PIKE SOLAR SITE DEVELOPMENT PLAN

PCD-ENGINEERING REVIEW COMMENTS
IN BLUE BOXES WITH BLUE TEXT

PIKE SOLAR PROJECT

1 AREA 3 - PLAN VIEW
G103 SCALE: 1"=350'

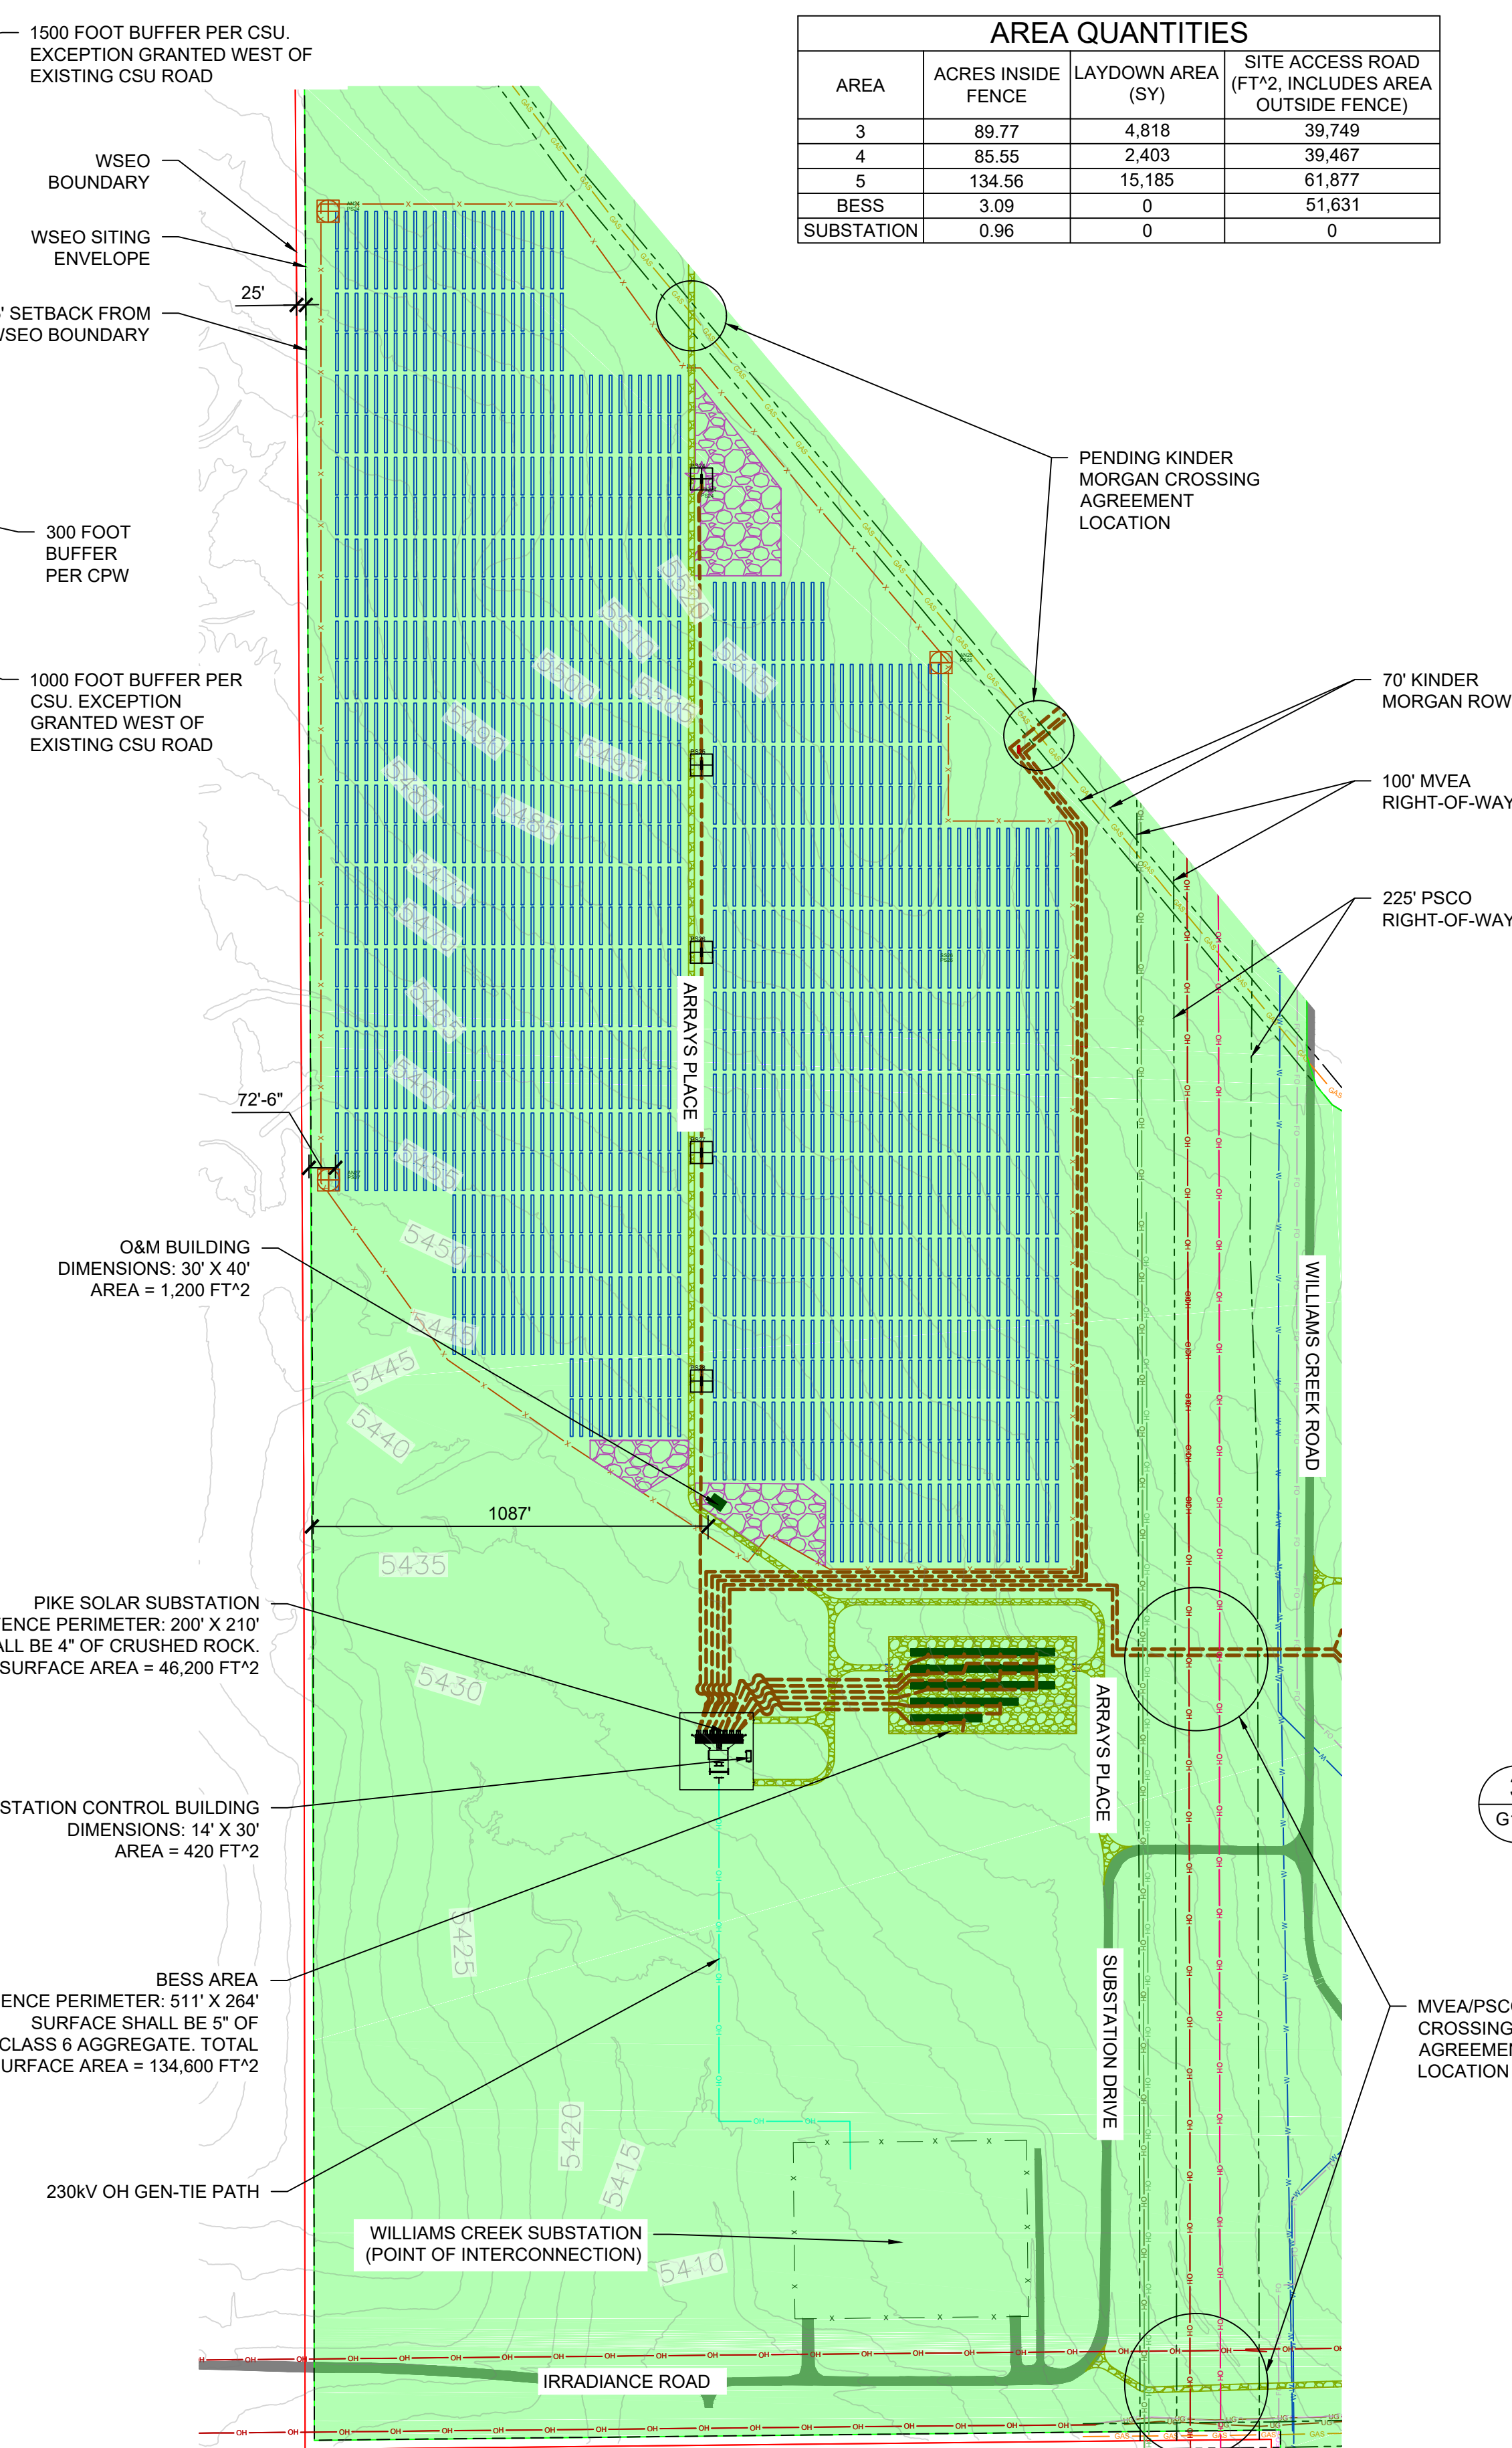
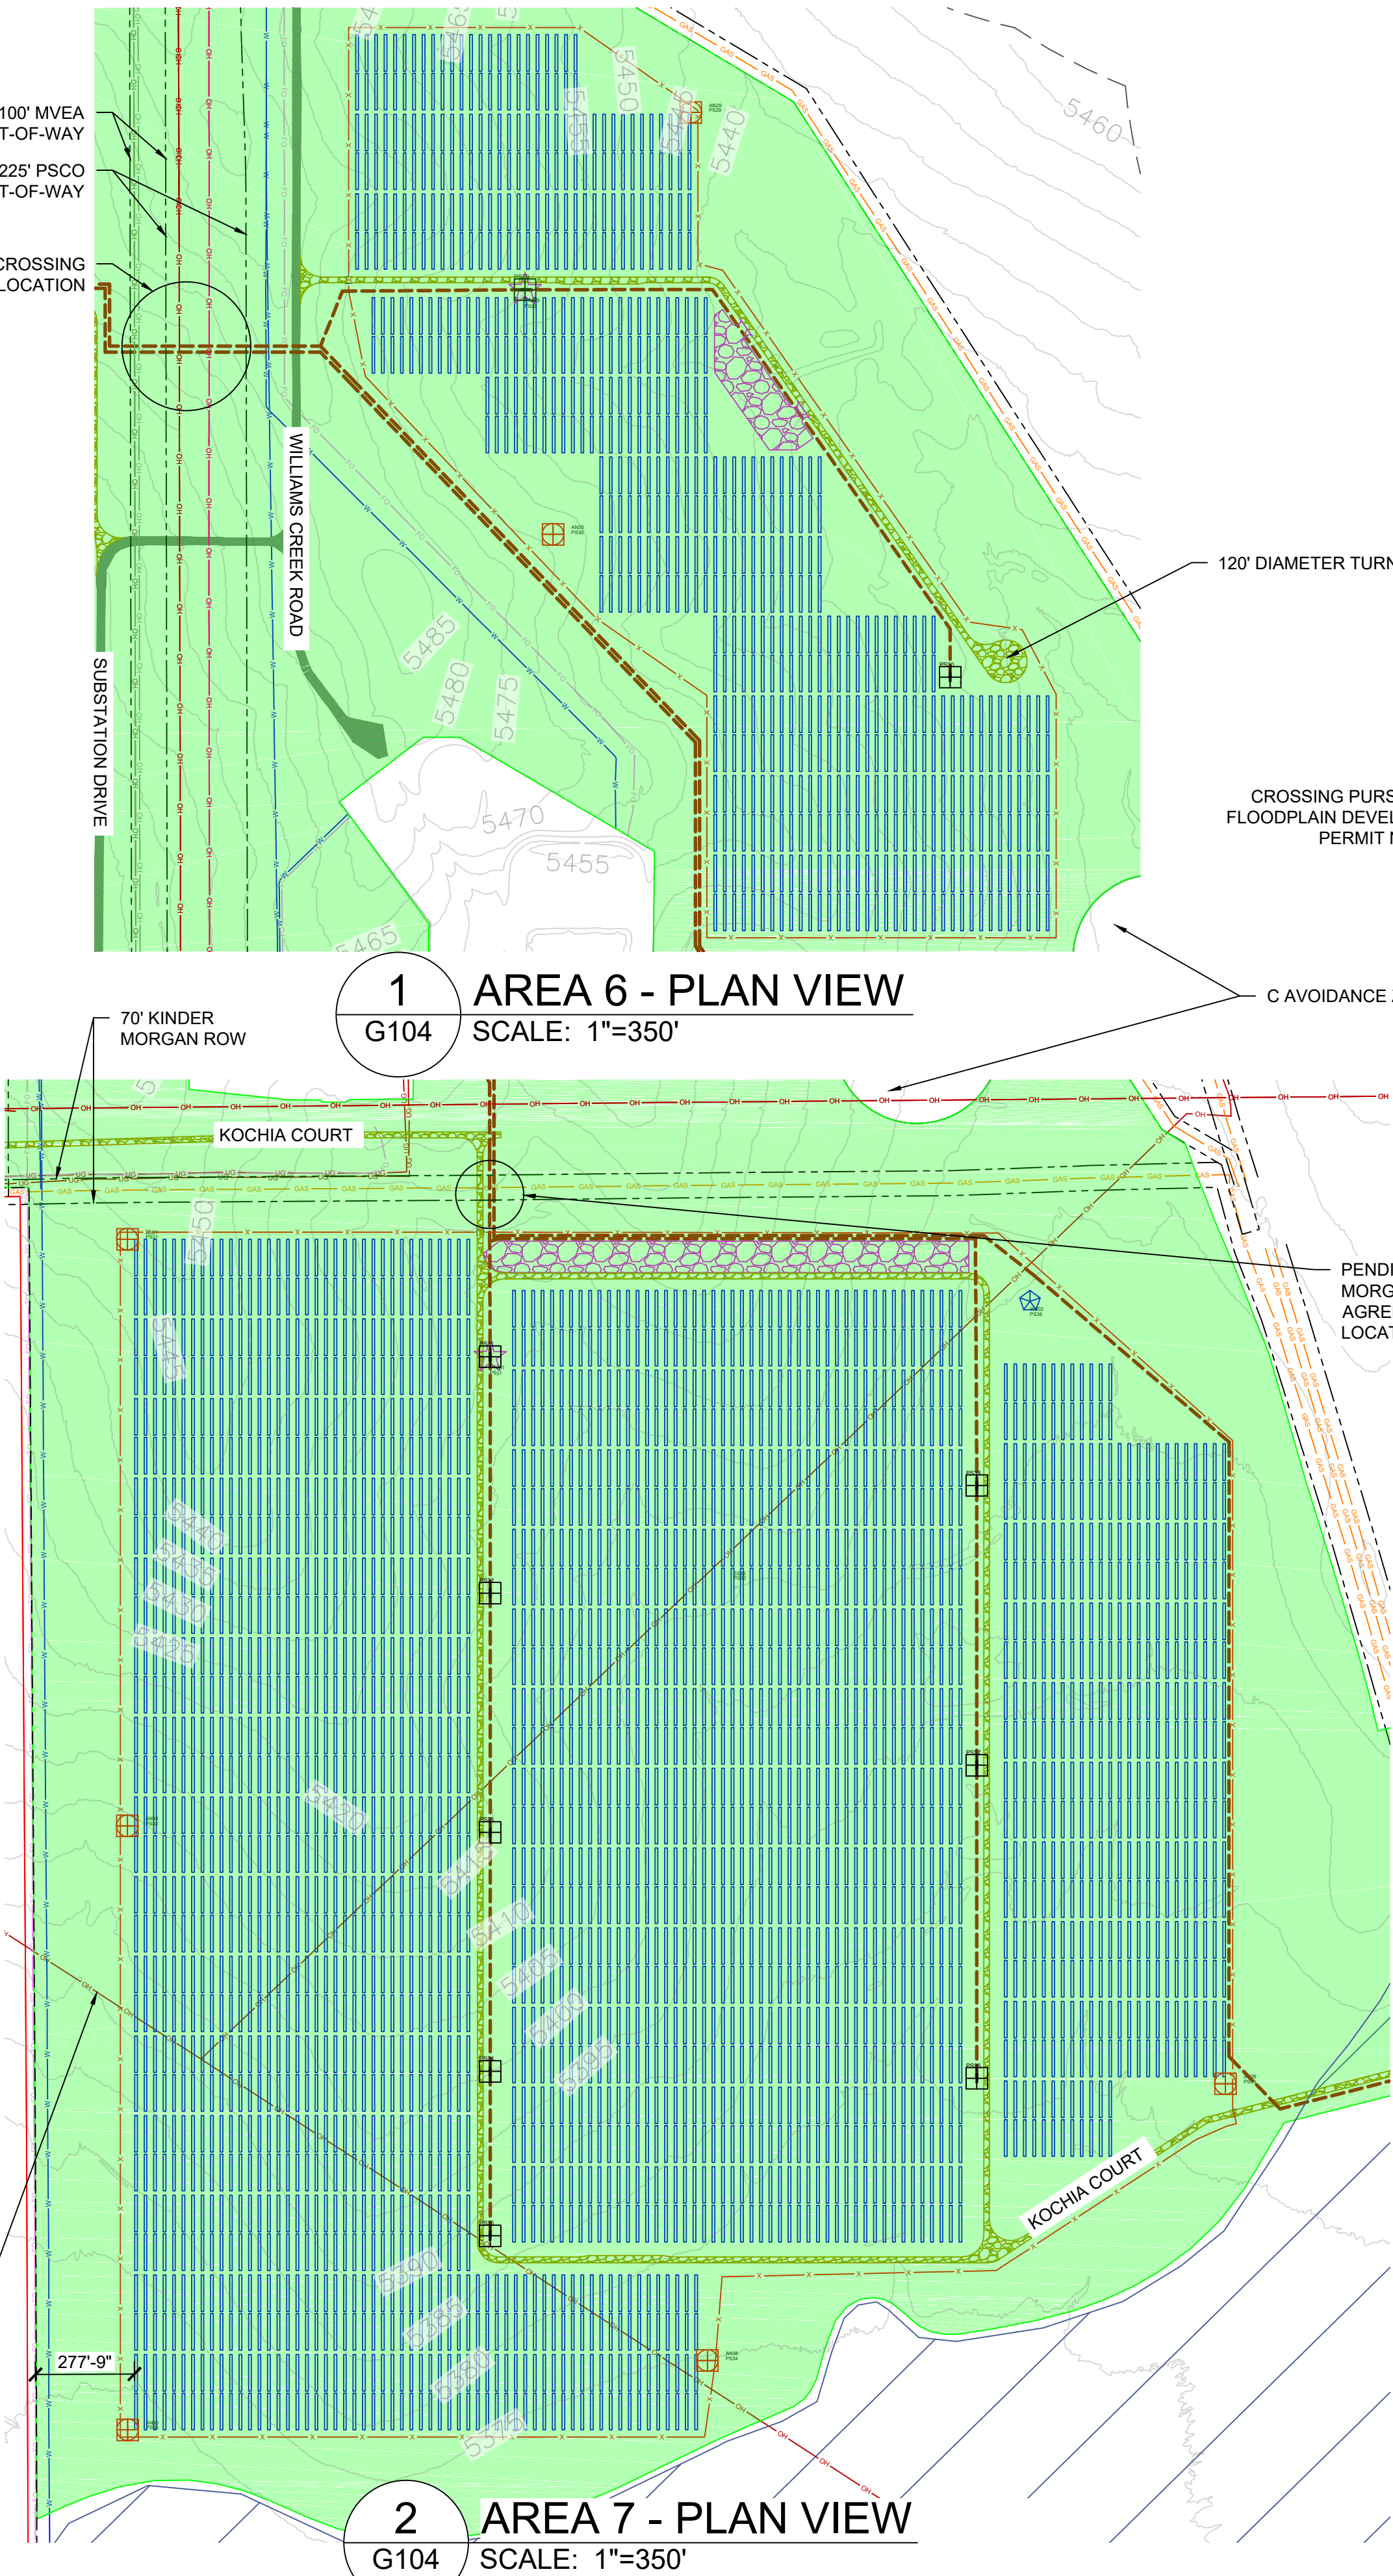
Provide details
and show on all
plans if there will
be a building.

please provide a
detail of the POLES
or the Overhead lines
both the 230 and 115;
add a sybol for the
powl locations along
the lines...All Gen site
plan sheets
